Your Ref: 000013992
Our Ref: BE/159/12/
Please ask for:
Mrs J Chapman

9th November 2012

Two storey side extension
24 Ashurst Close North Bersted

PROPOSED FIRST FLOOR

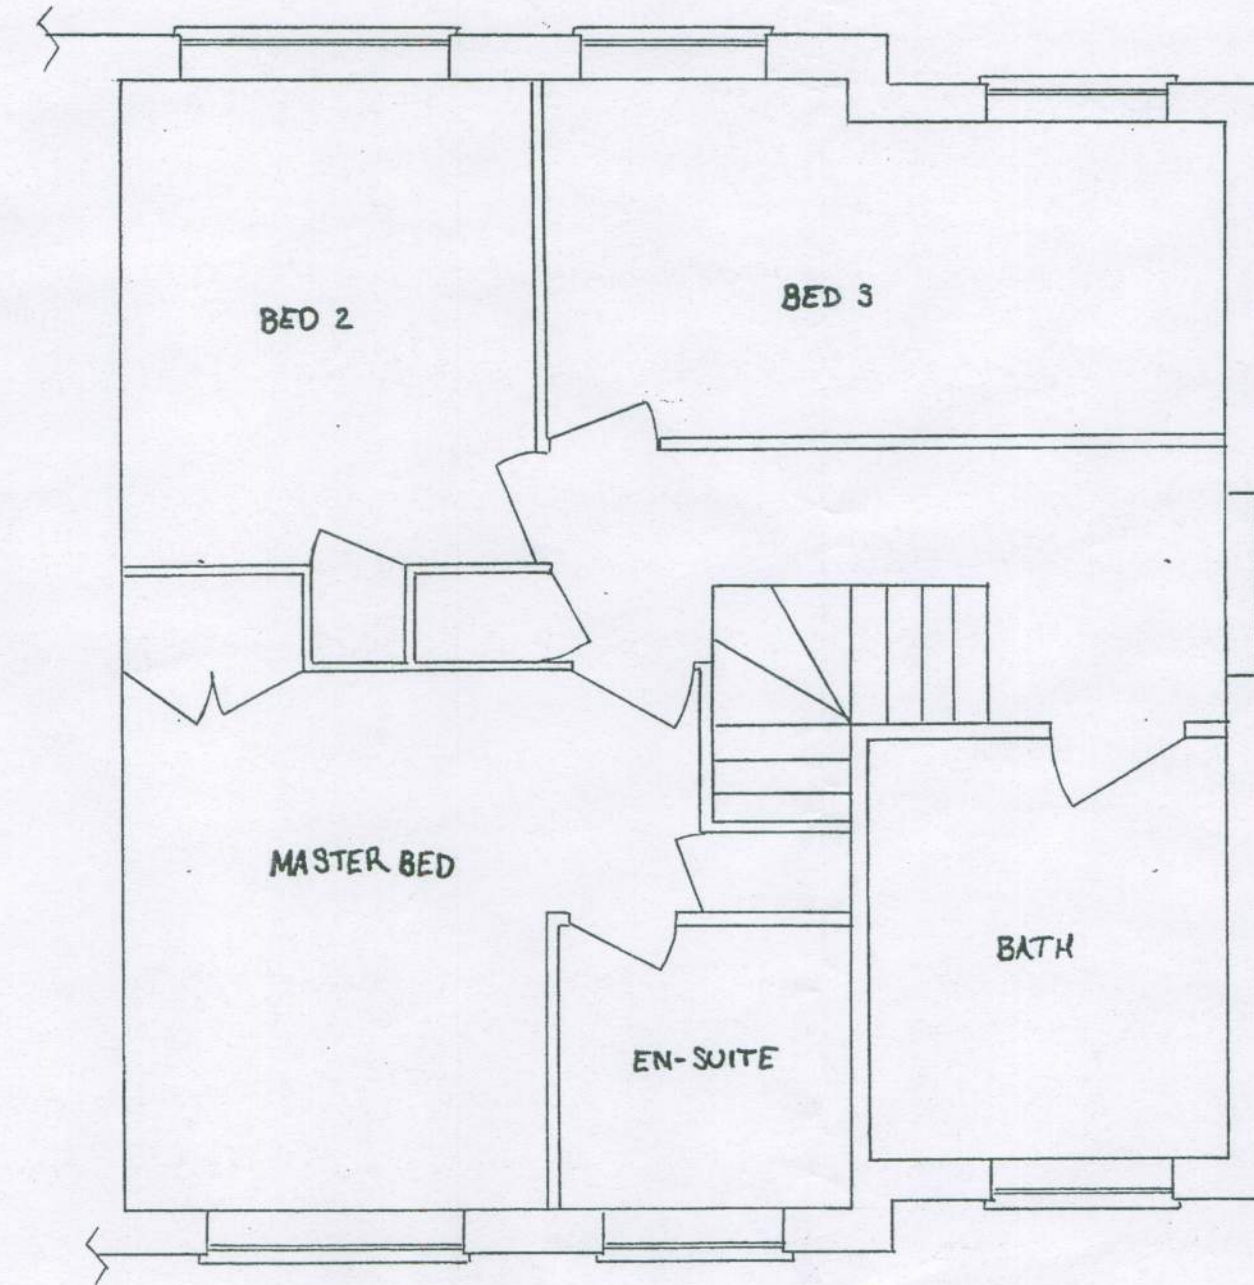
No Objection, but council would like the rear window to be obscure glass and there is a 2m boundary space from the neighbouring fence.
